DRB CASE ACTION LOG (SITE PLAN B.P.)

DRB Application No.: 05DRB-01373 (SBP)

Project # 1004244

Project Name: MESA VILLAGE ADDITION

PLAT OF TRACT A
ST. PAUL'S UNITED METHODIST CHURCH

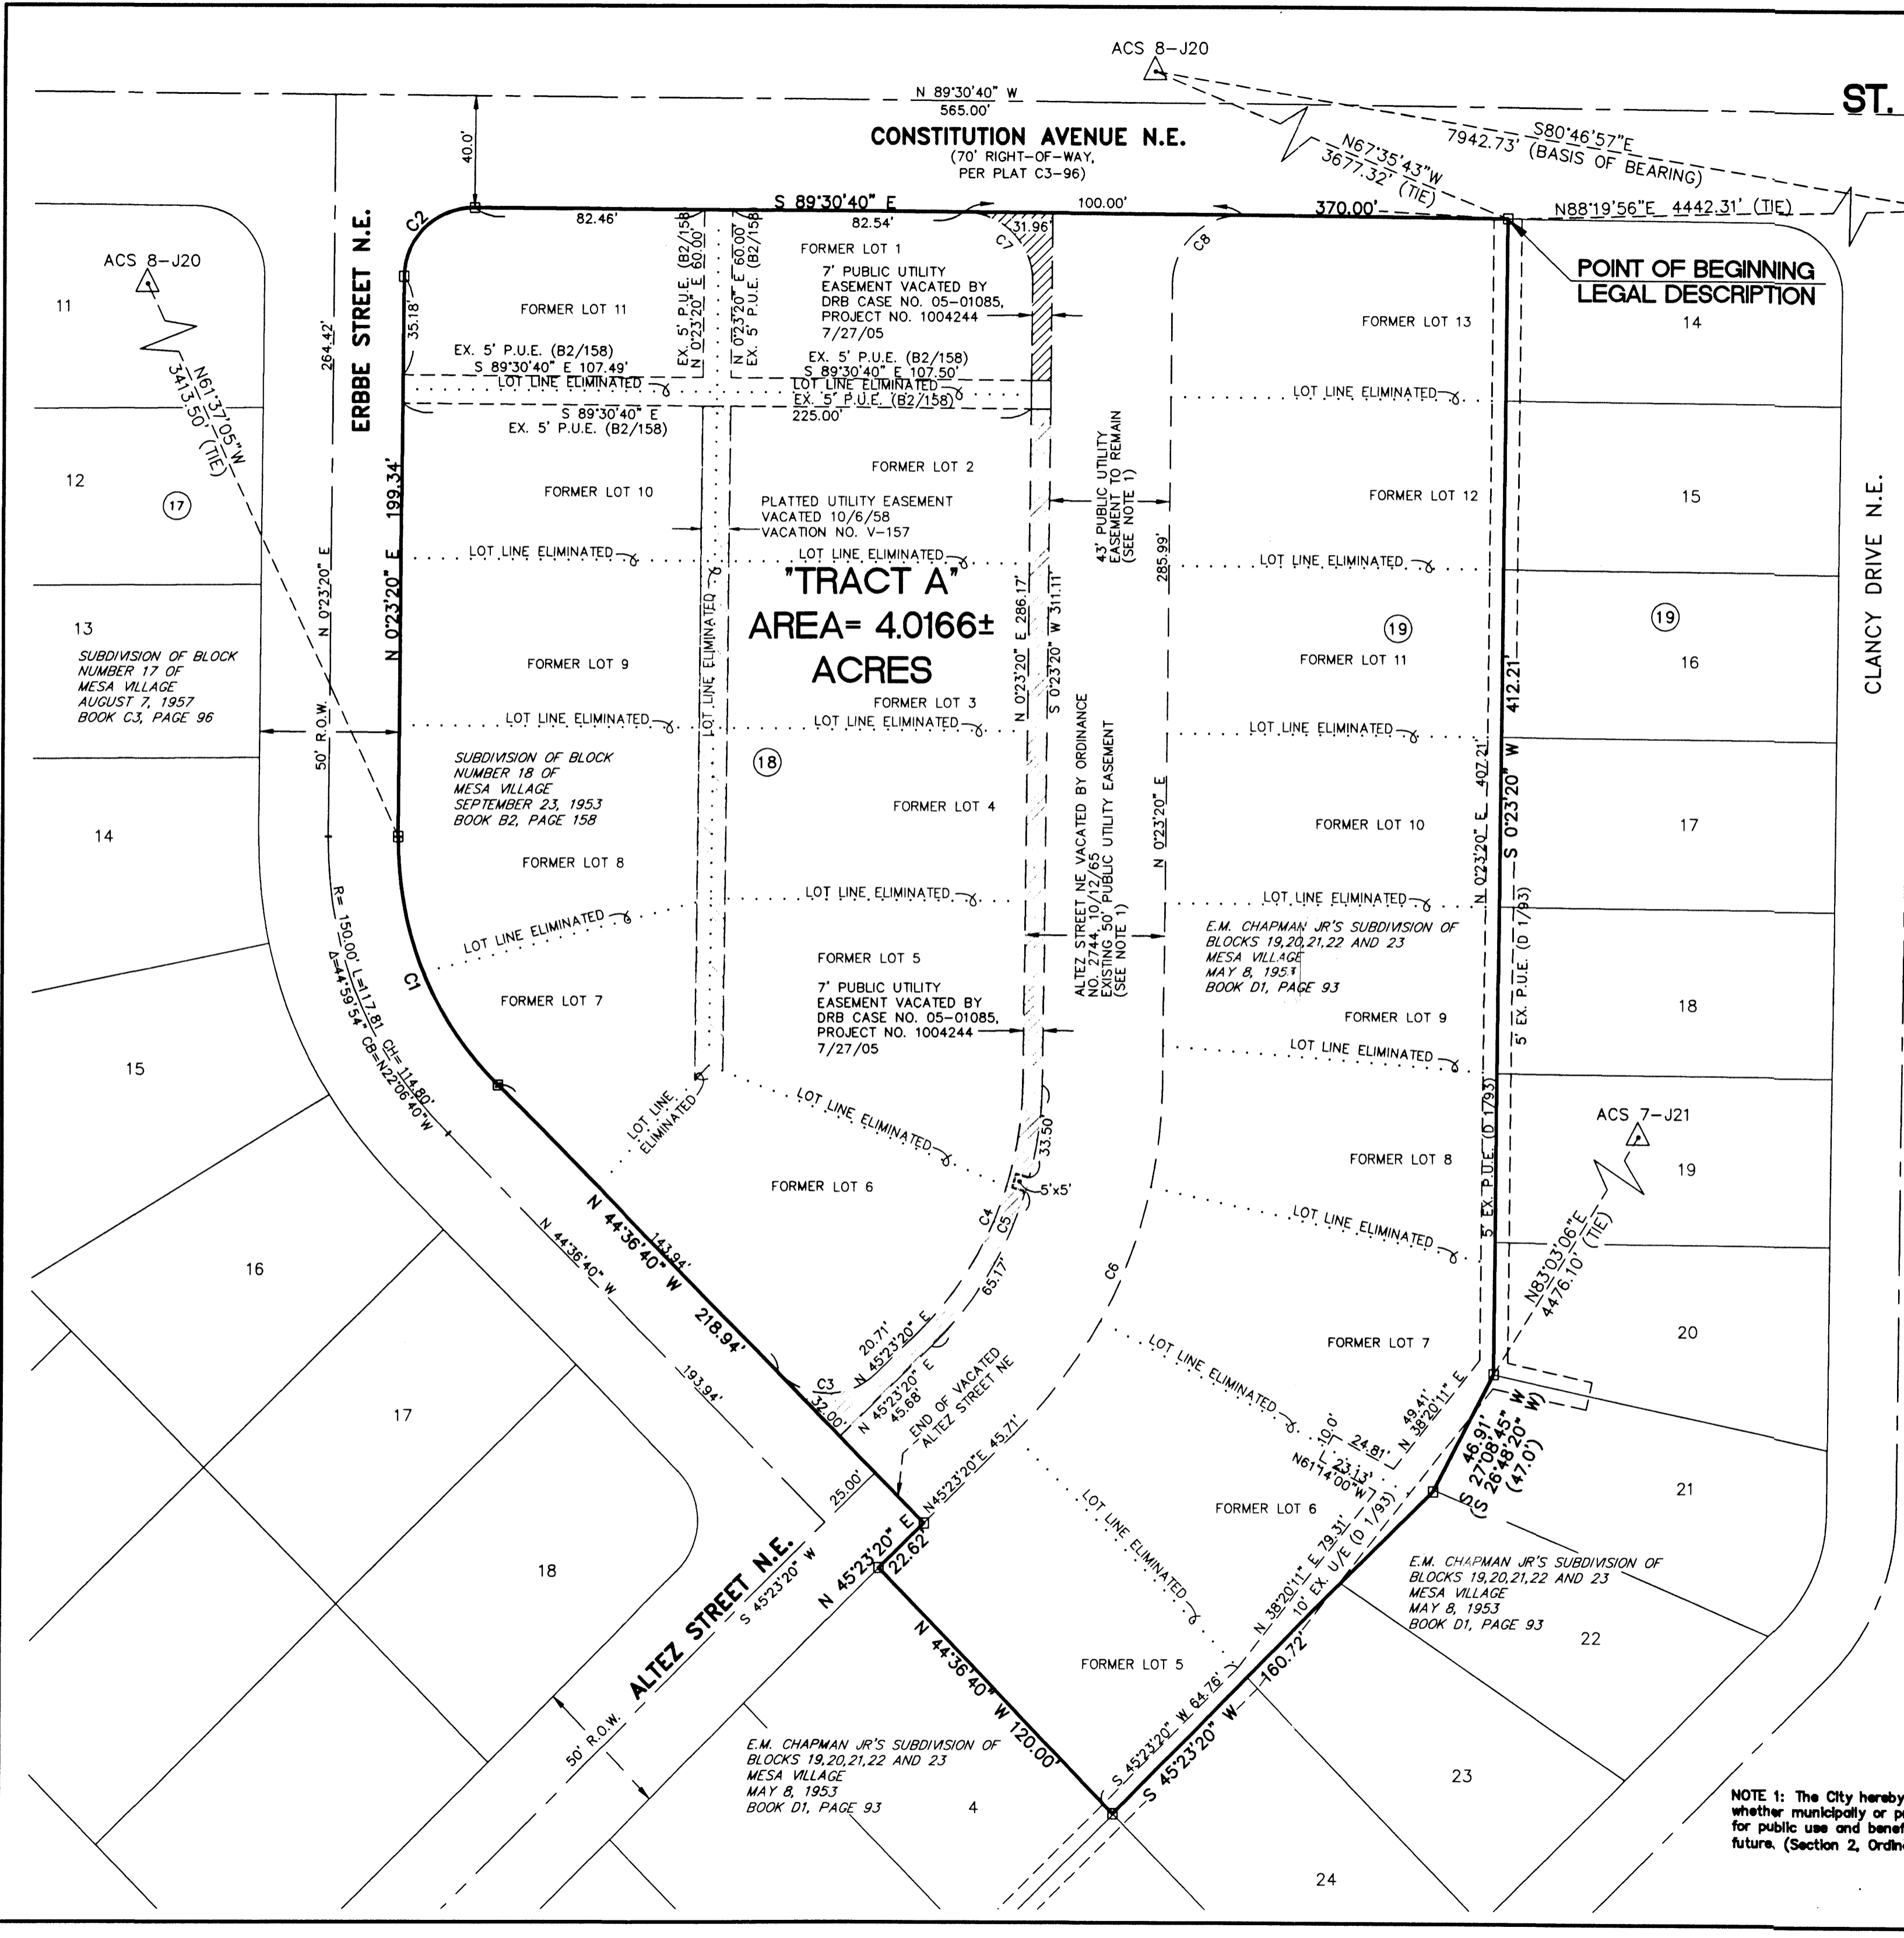
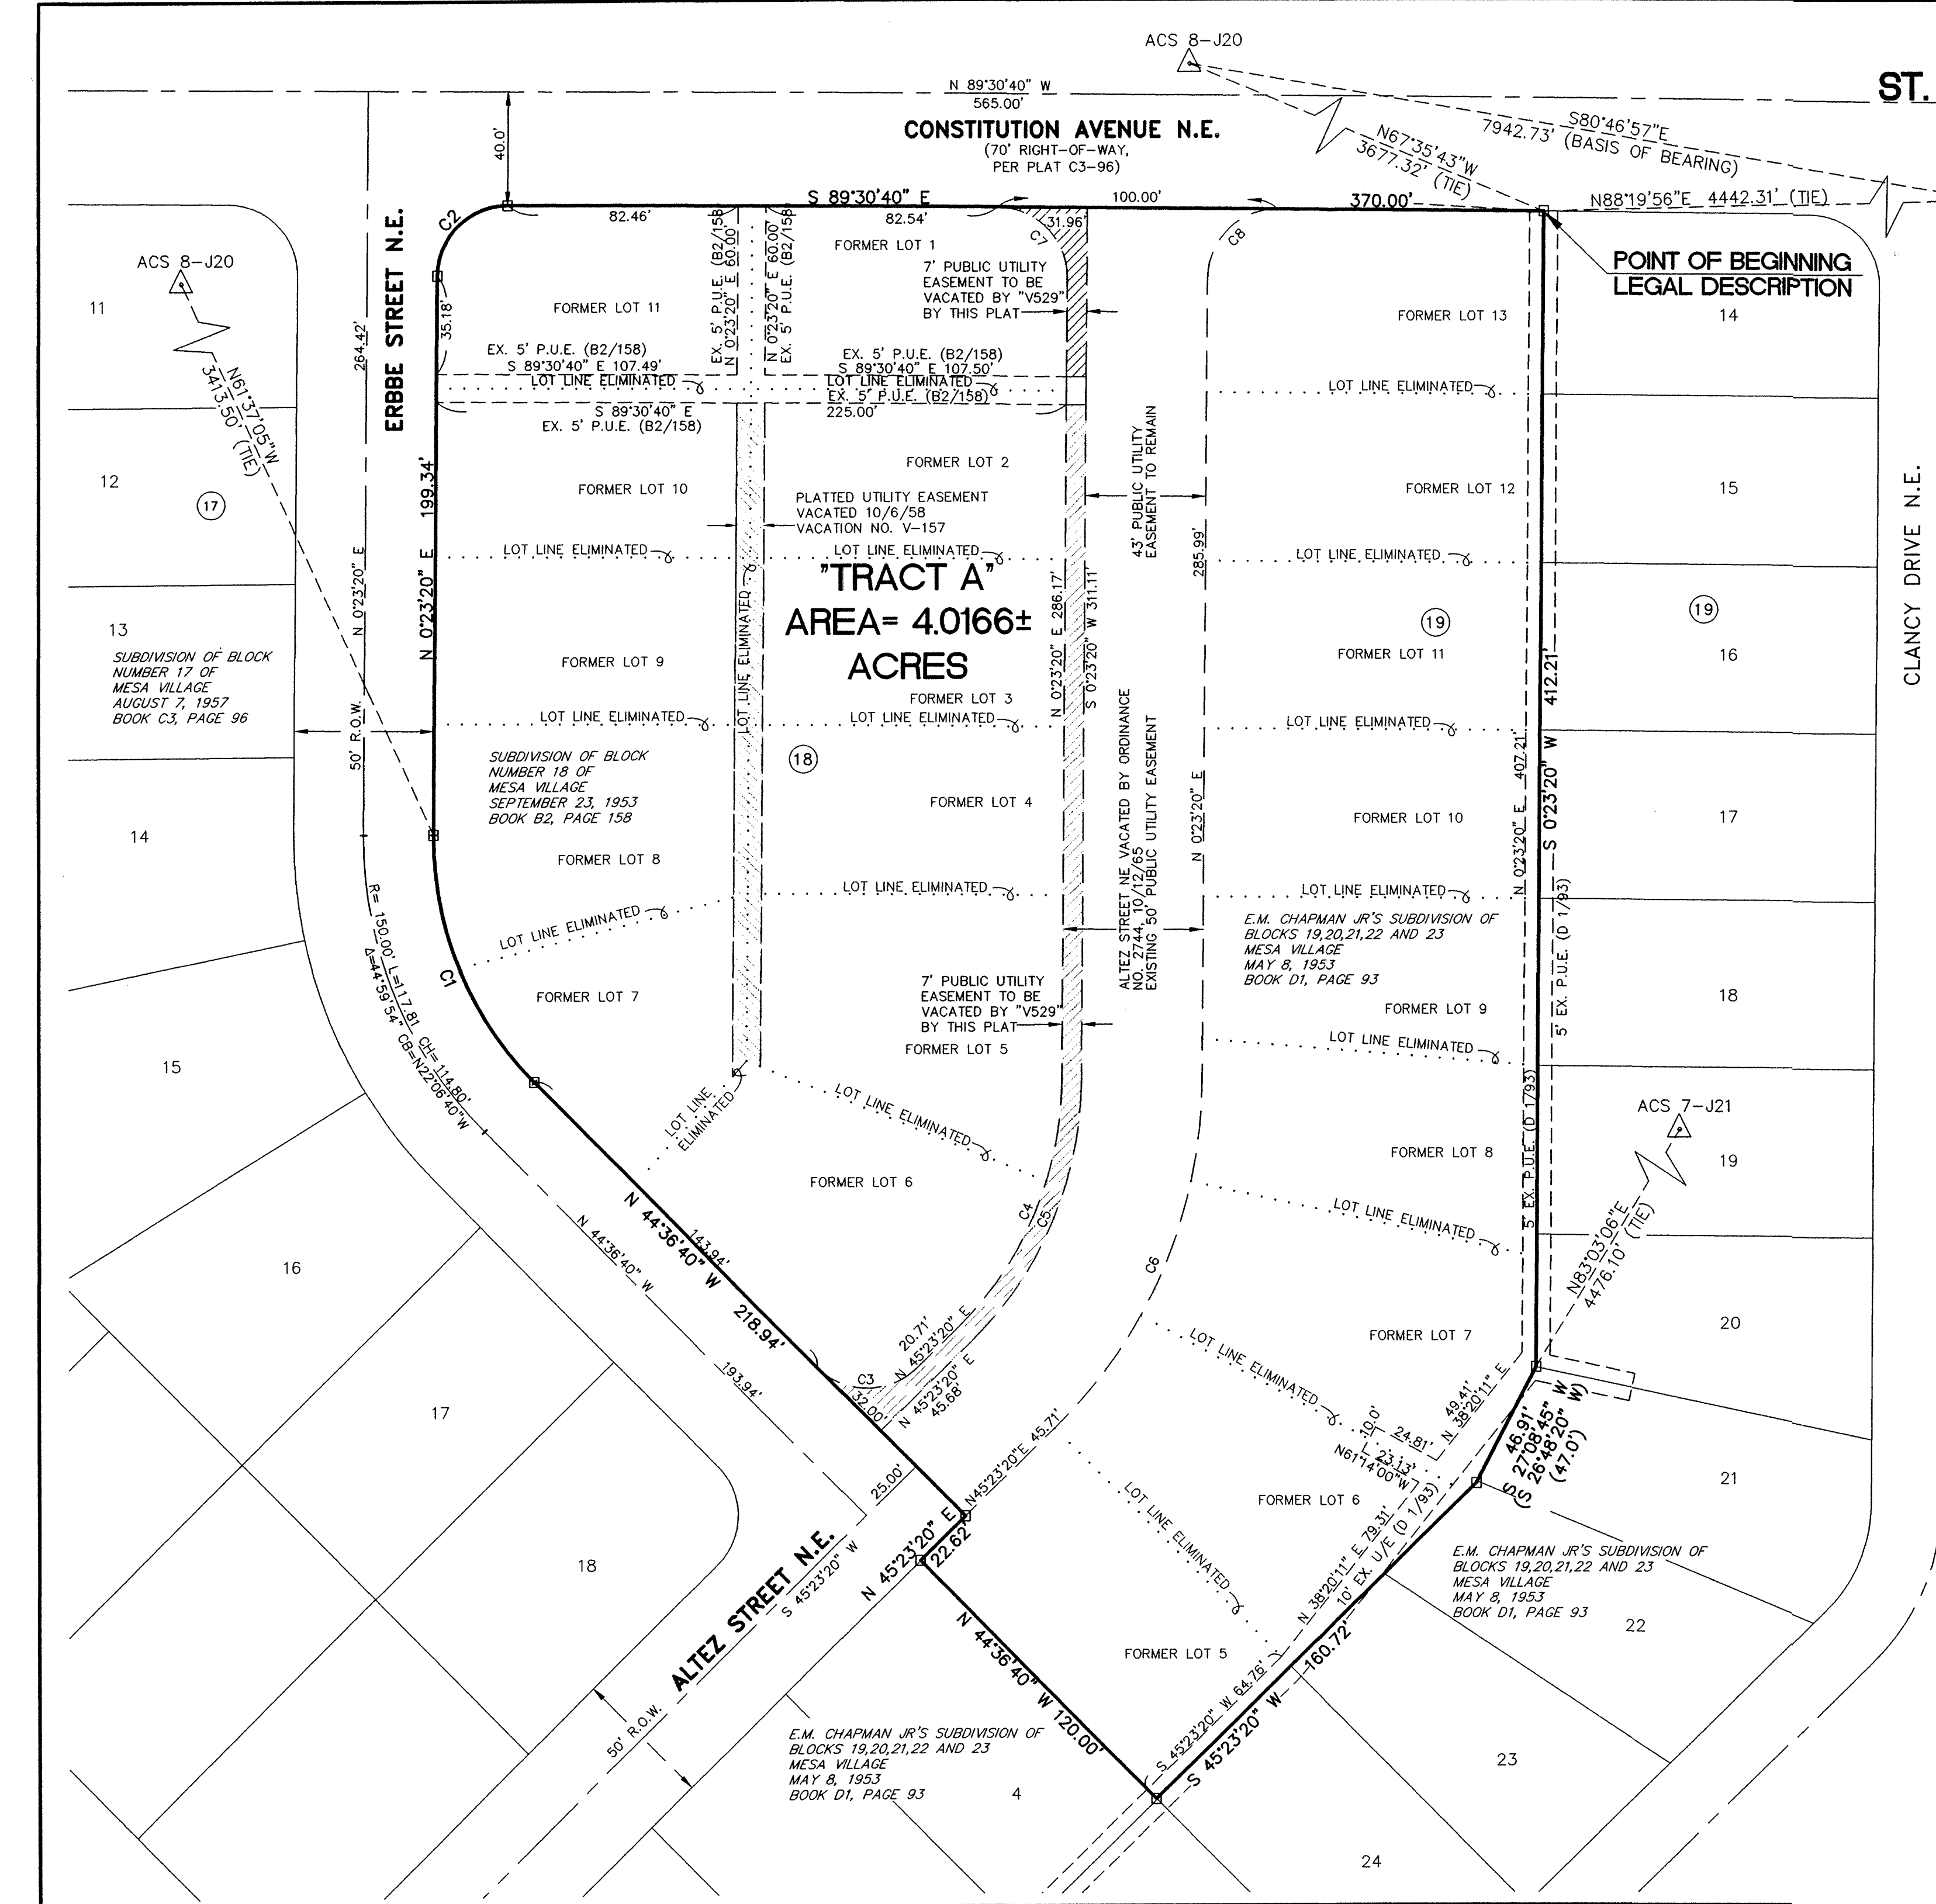
UTILITIES: adjust easement to include all existing meters
- add language from original Vacation Ordinance
for retained easements.
